ENGLISH HERITAGE  
NORTH WEST OFFICE

15 August 2012

**Notifications under Circular 01/2001, Circular 08/2009 & GDPO 1995**  
**BAILEY HALL BARN, HURST GREEN, LANCASHIRE**  
**Application No 3/2012/0602**

As Proposed
Sections

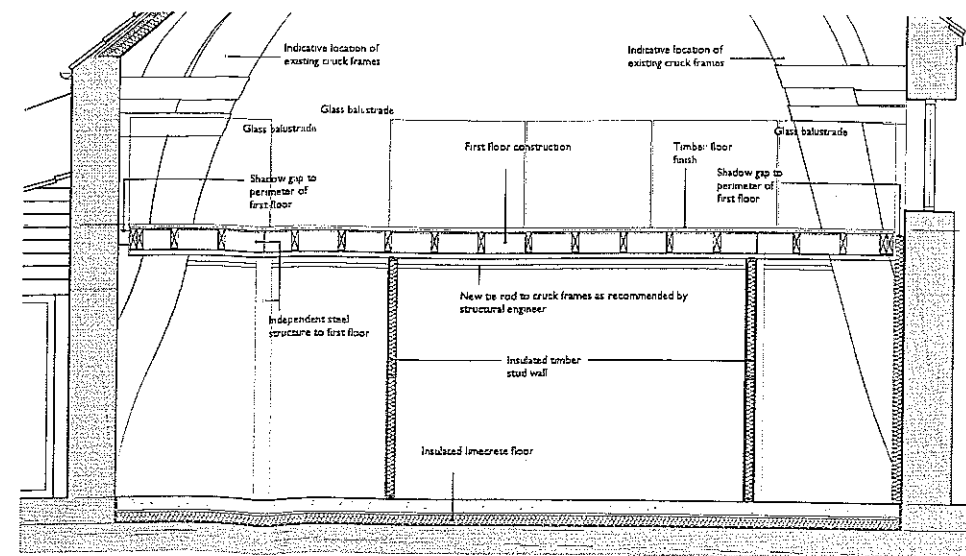
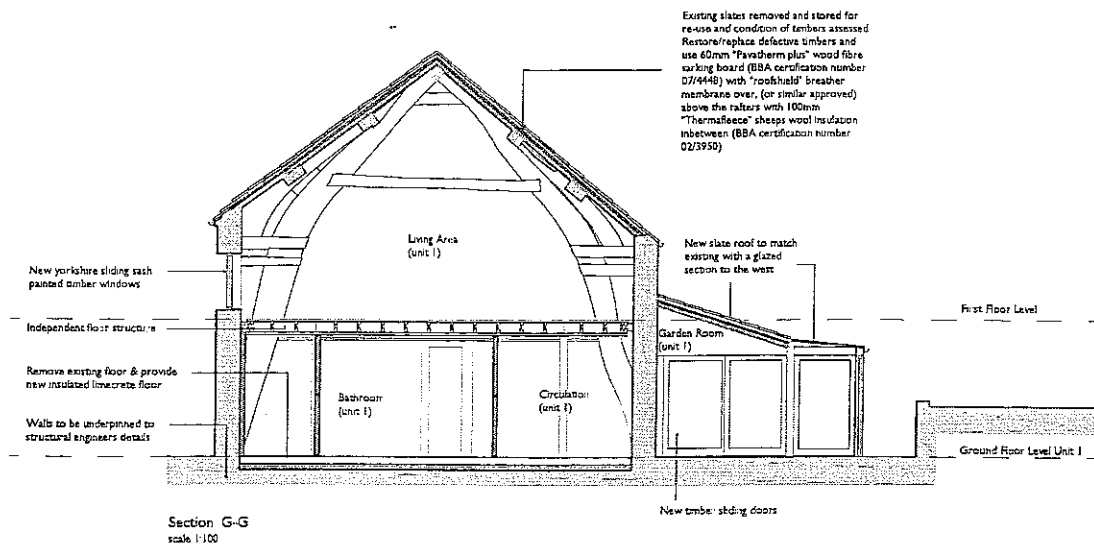
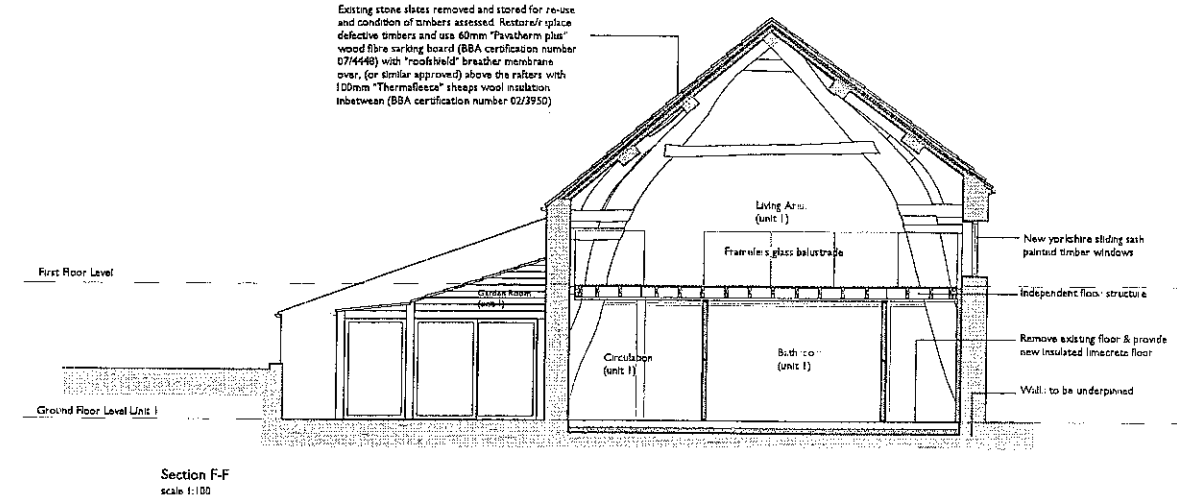
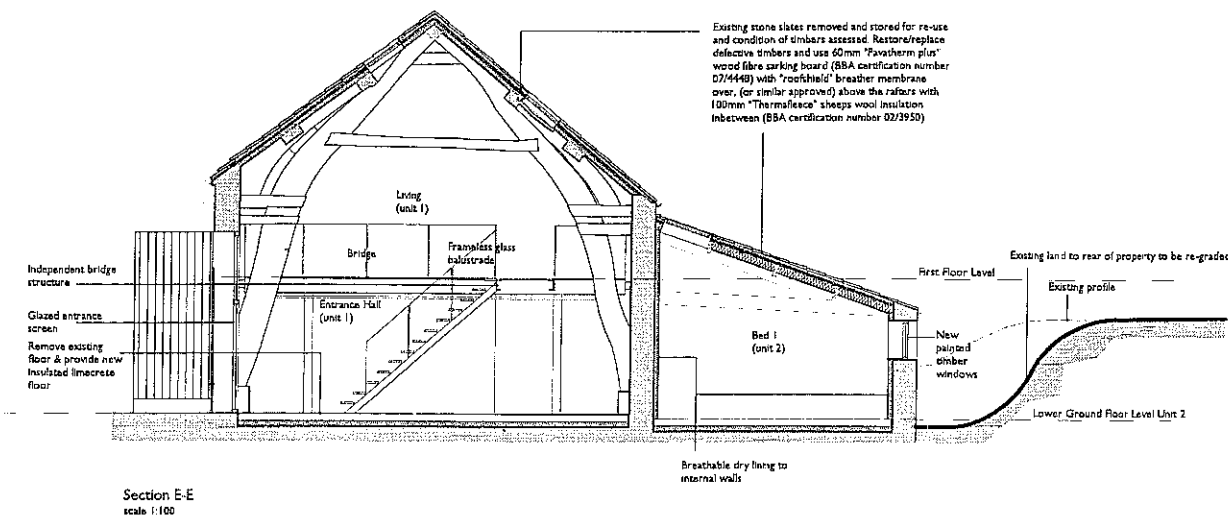
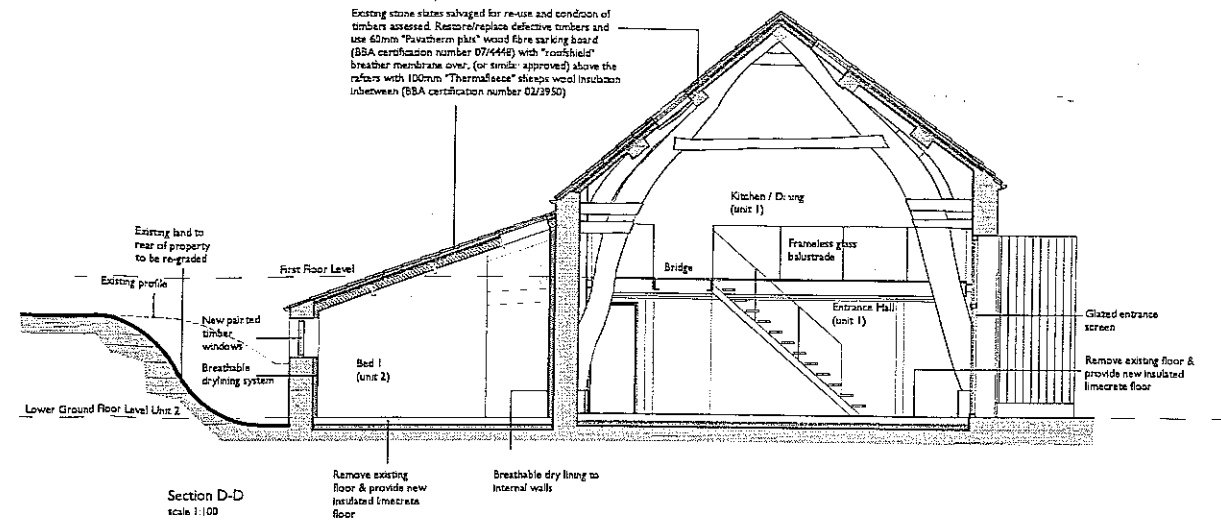
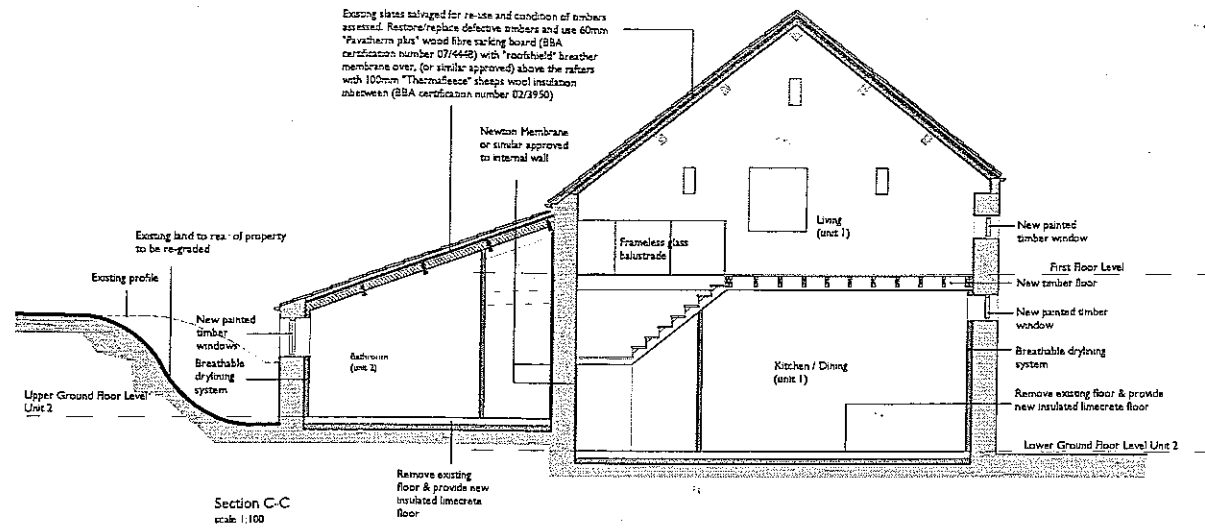
We welcome the proposal to install an essentially free-standing and independent steel structure within the barn which allows for minimal intervention to the historic fabric. We would request, however, that the need for re-introducing steel tie rods between the cruck trusses is examined carefully.

As Proposed
Repair and Alterations

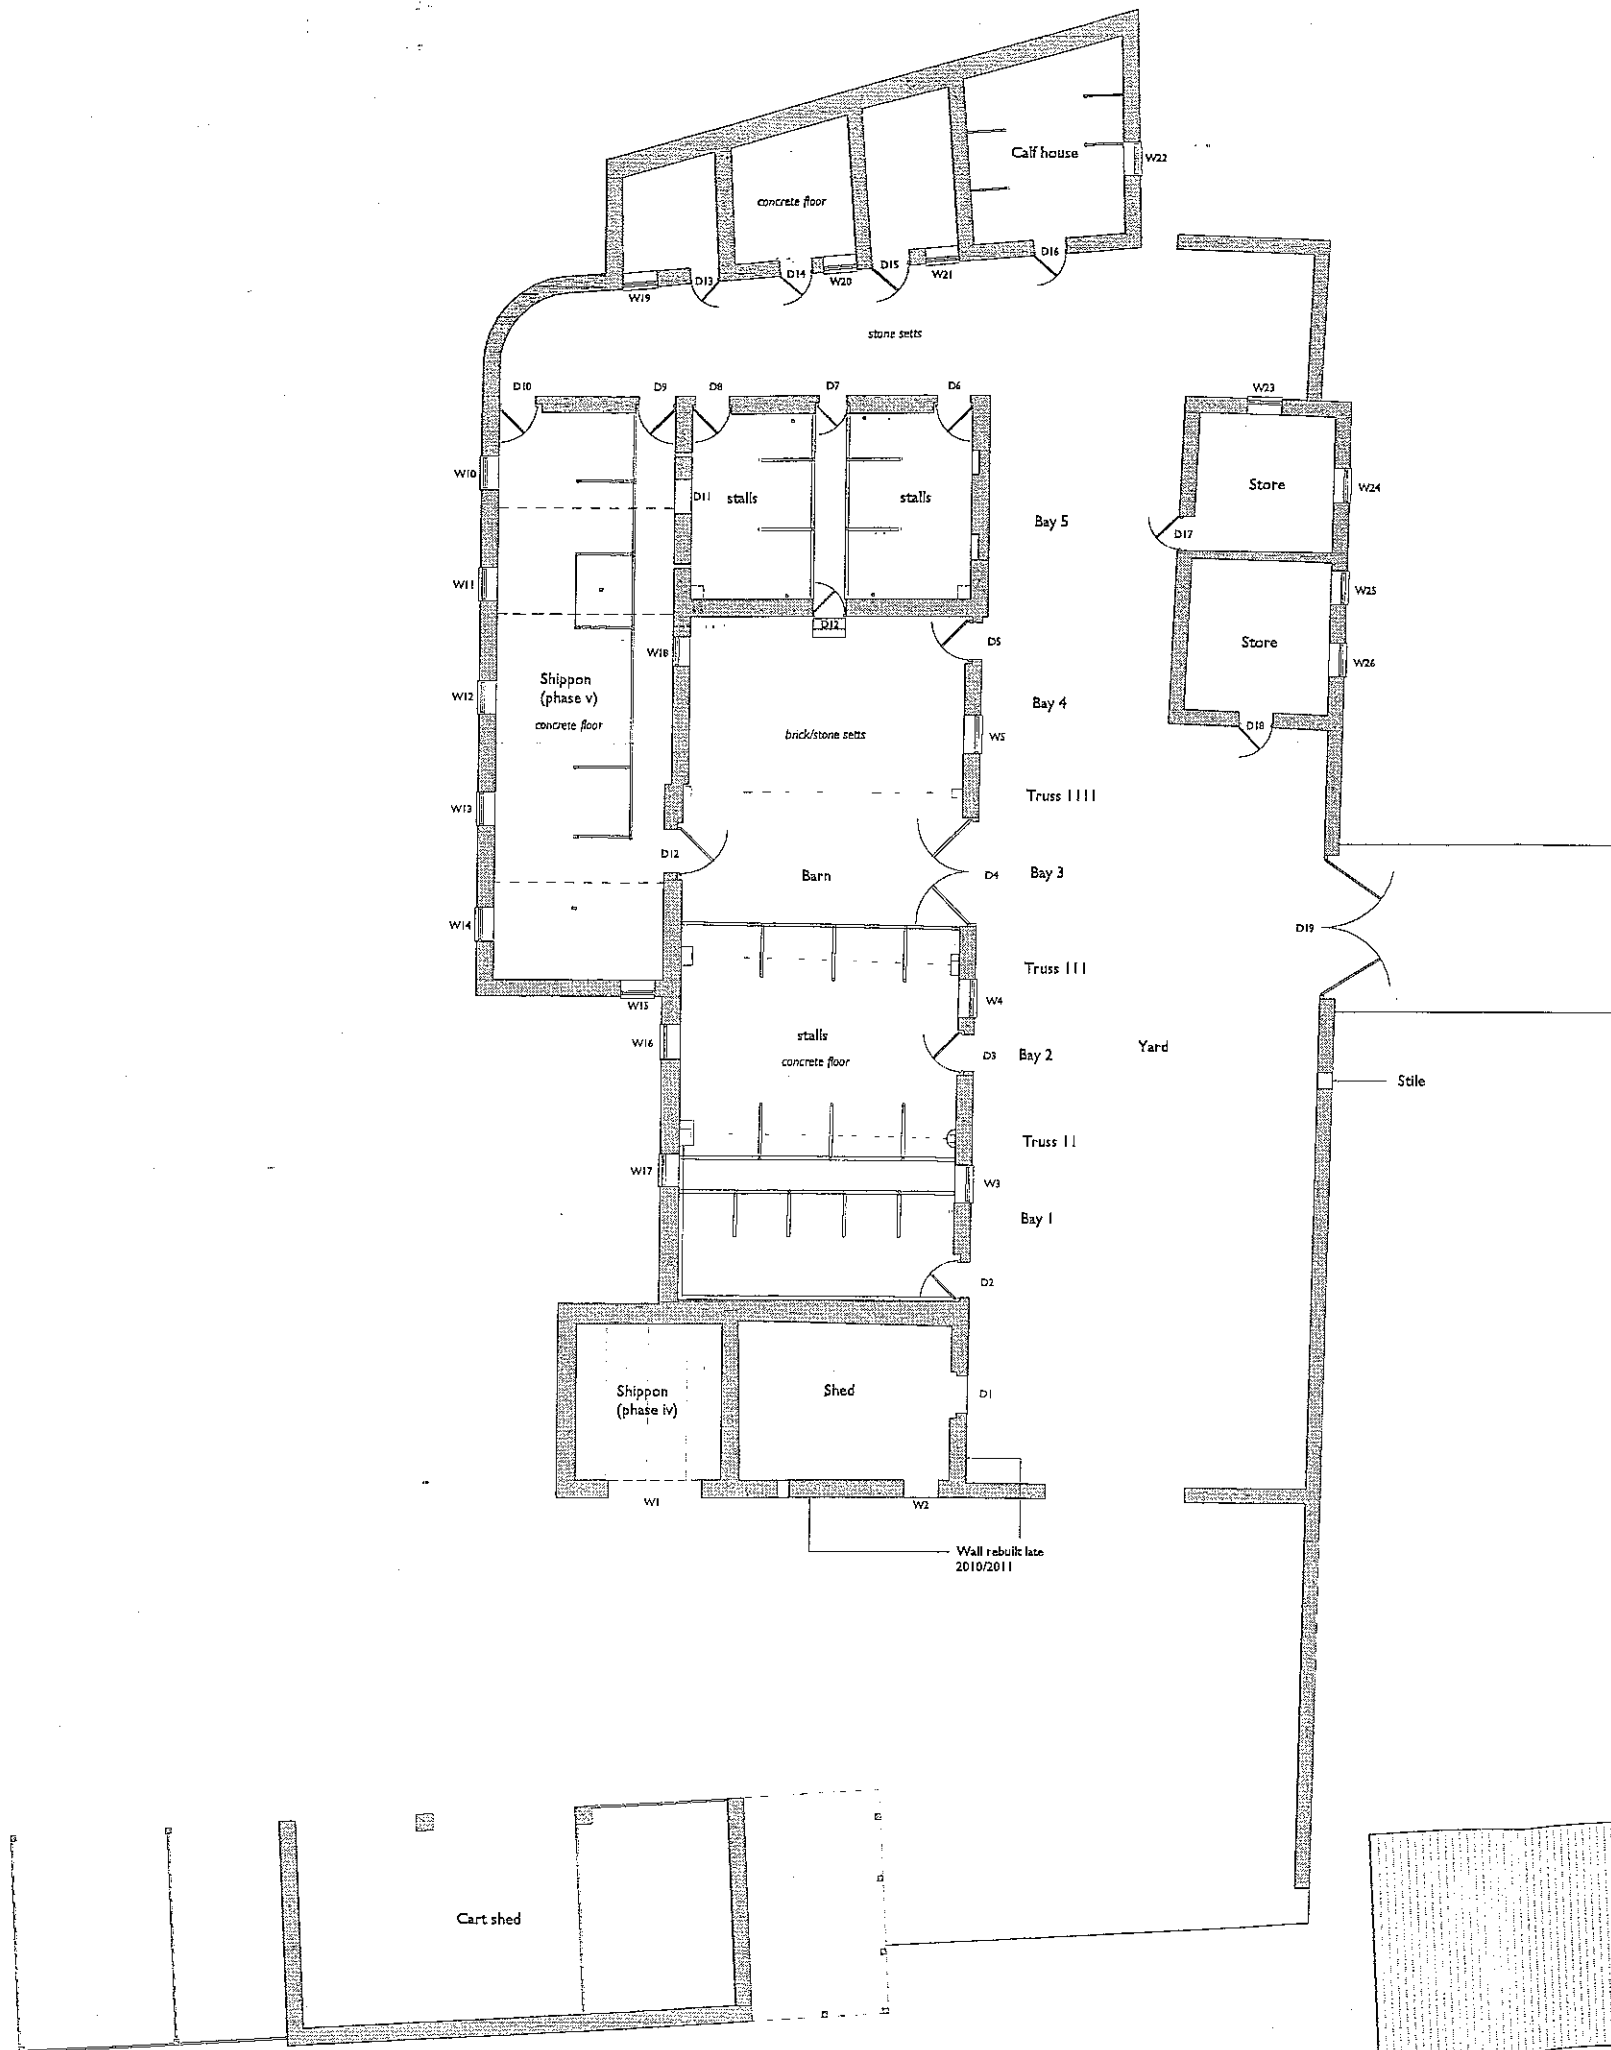
It is desirable that the padstones and dwarf walls are retained *in situ* as these represent architecturally interesting elements of the building that contribute to its significance. Similarly we would not support the removal or alteration of the closed truss box-frame.
